FLYING HORSE NORTH FILING NO. 7

FILE NO. FS 2532

FLYING HORSE NORTH FILING NO. 7
PLAT

DRAWN BY	TRN
CHECKED BY	JWT
H-SCALE	N/A
JOB NO.	2417-08
DATE CREATED	11/17/25
DATE ISSUED	DRFT
SHEET NO	1 OF 5

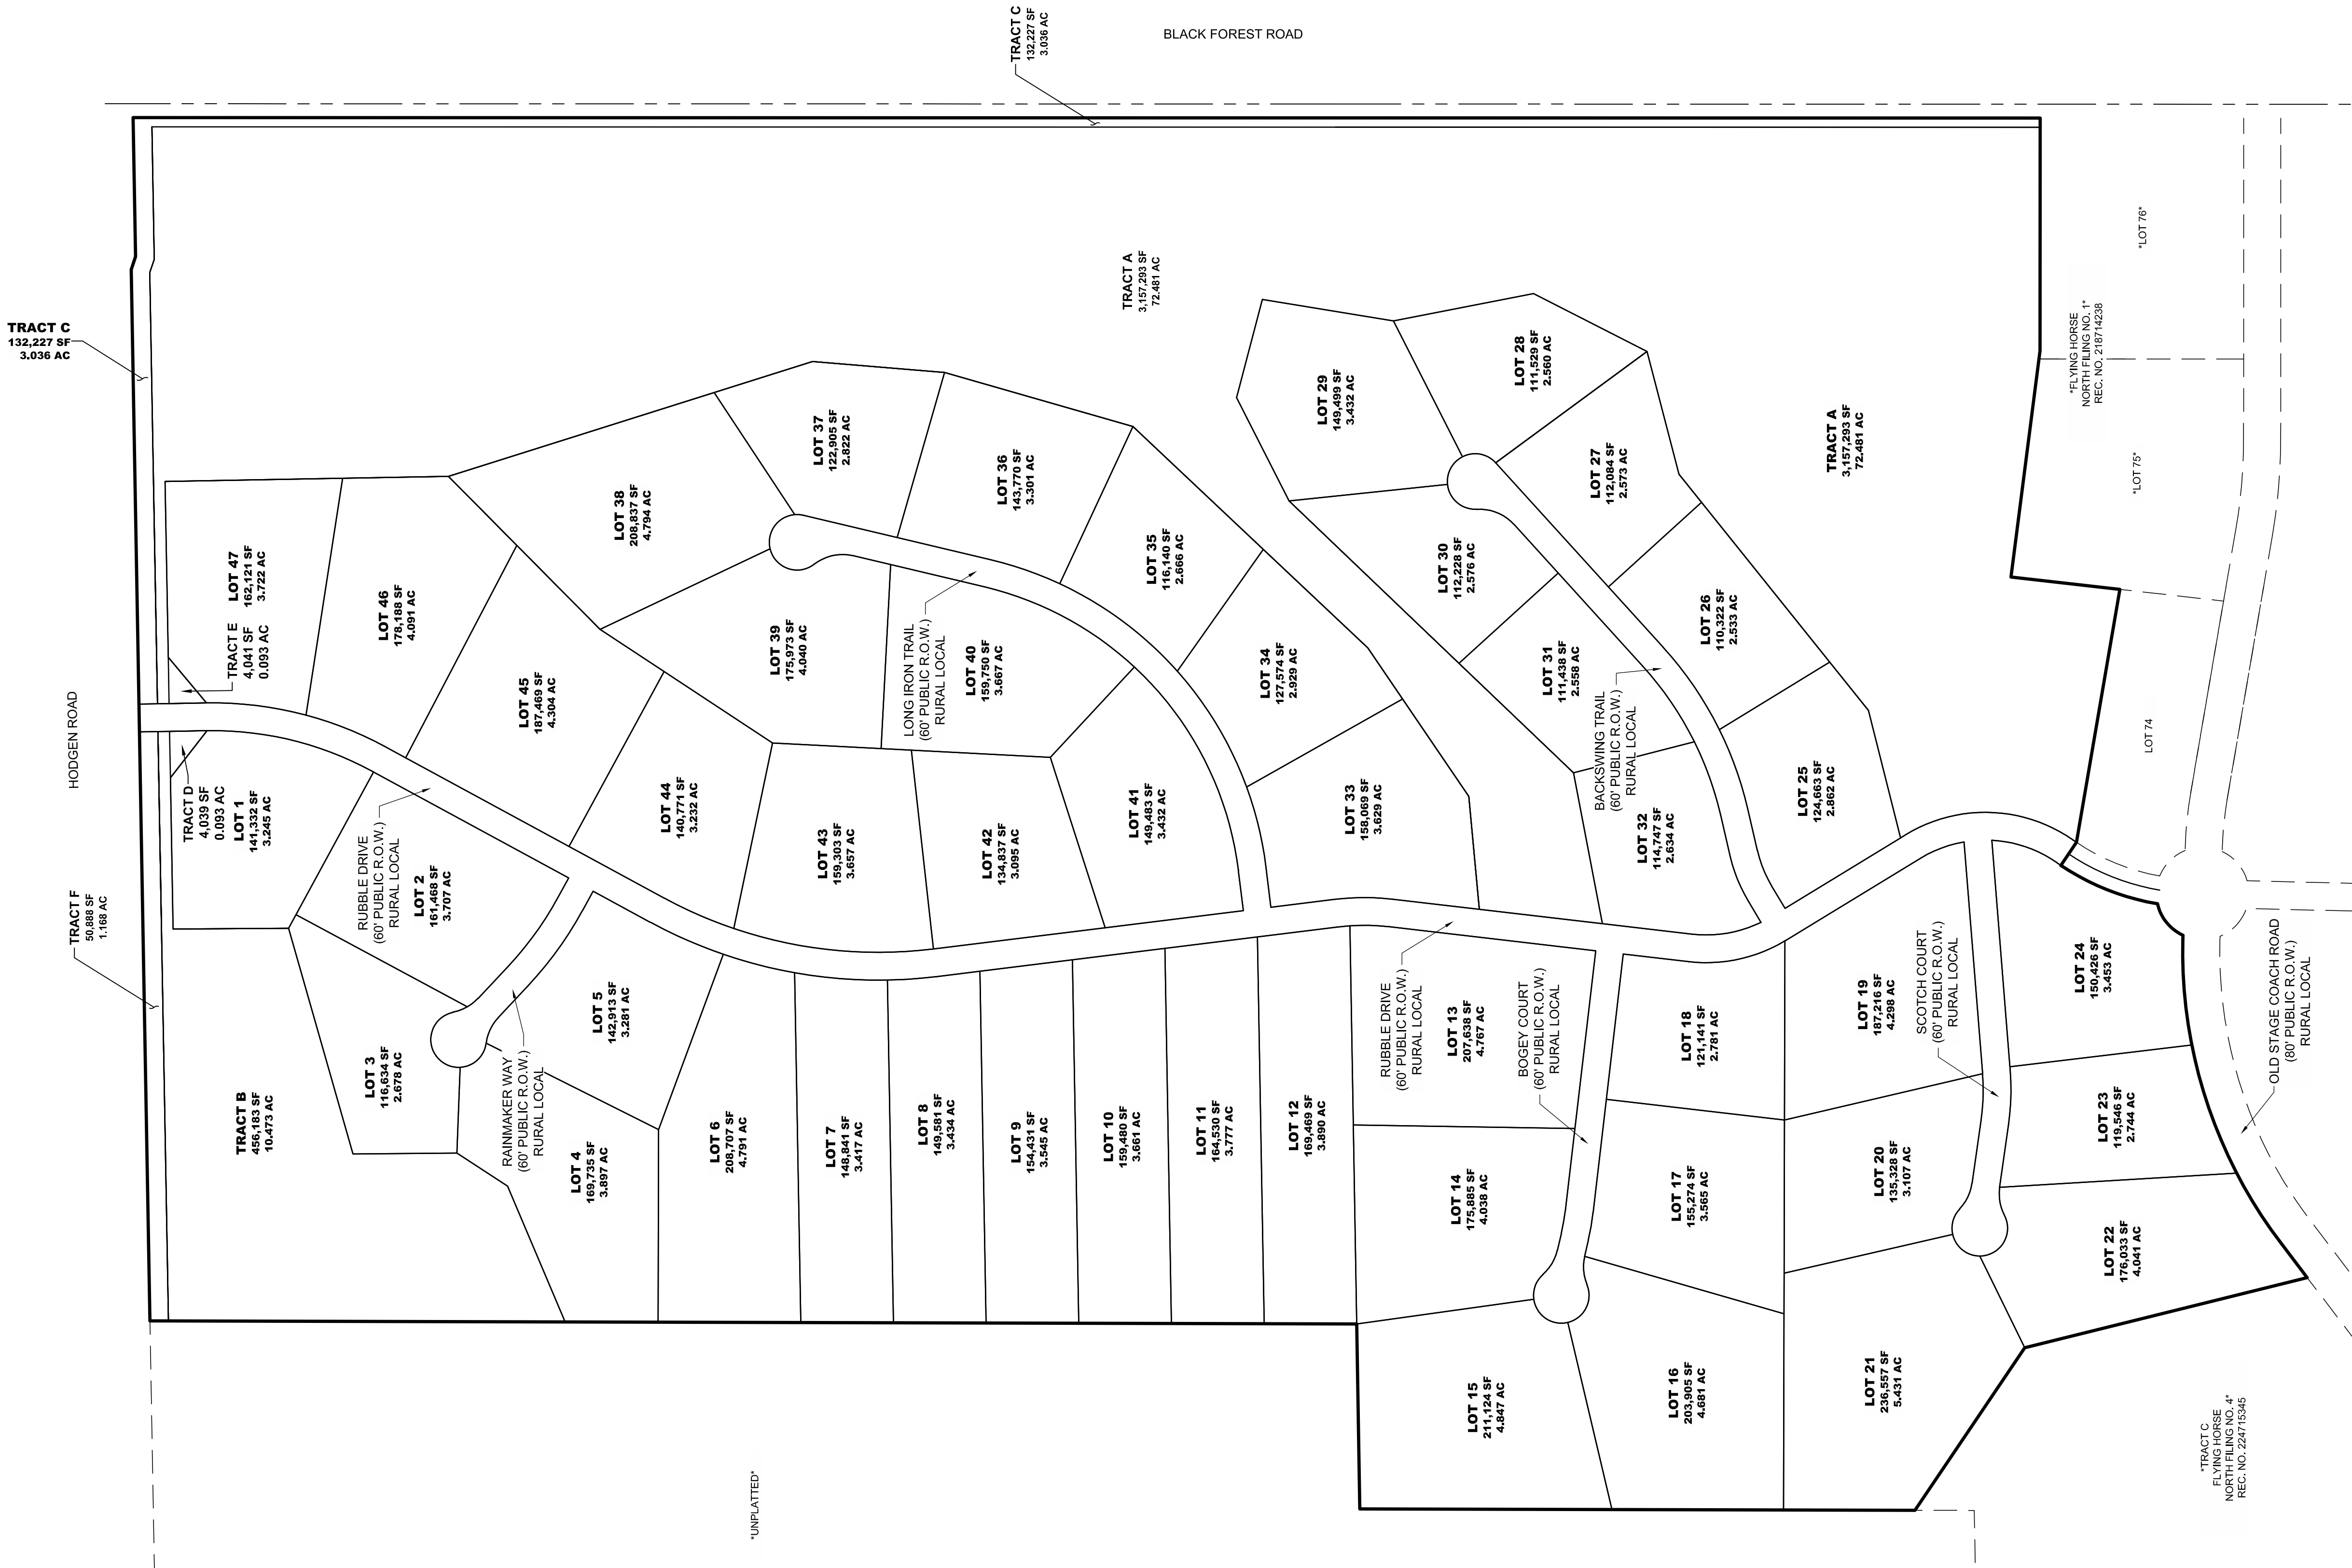
Unresolved previous comment from Review 1 and 2:
Please add plat note(s) specifically discussing the purpose and responsibility of each plat tract ["plat" was my typo from the previous 2 reviews, and thus maybe why this comment has gone unresolved]. The County Attorney has informed us that plat tables with tracts are not legally enforceable. Go-by note provided below.

Added note as line item 32.

Please delete. This plat note is only needed when the Large Lot WQ Exclusion is utilized. Since you are not using that exclusion, don't limit the lot % imperviousness to 10% and require owners to do the study if the % is 10-20

Deleted this plat note.
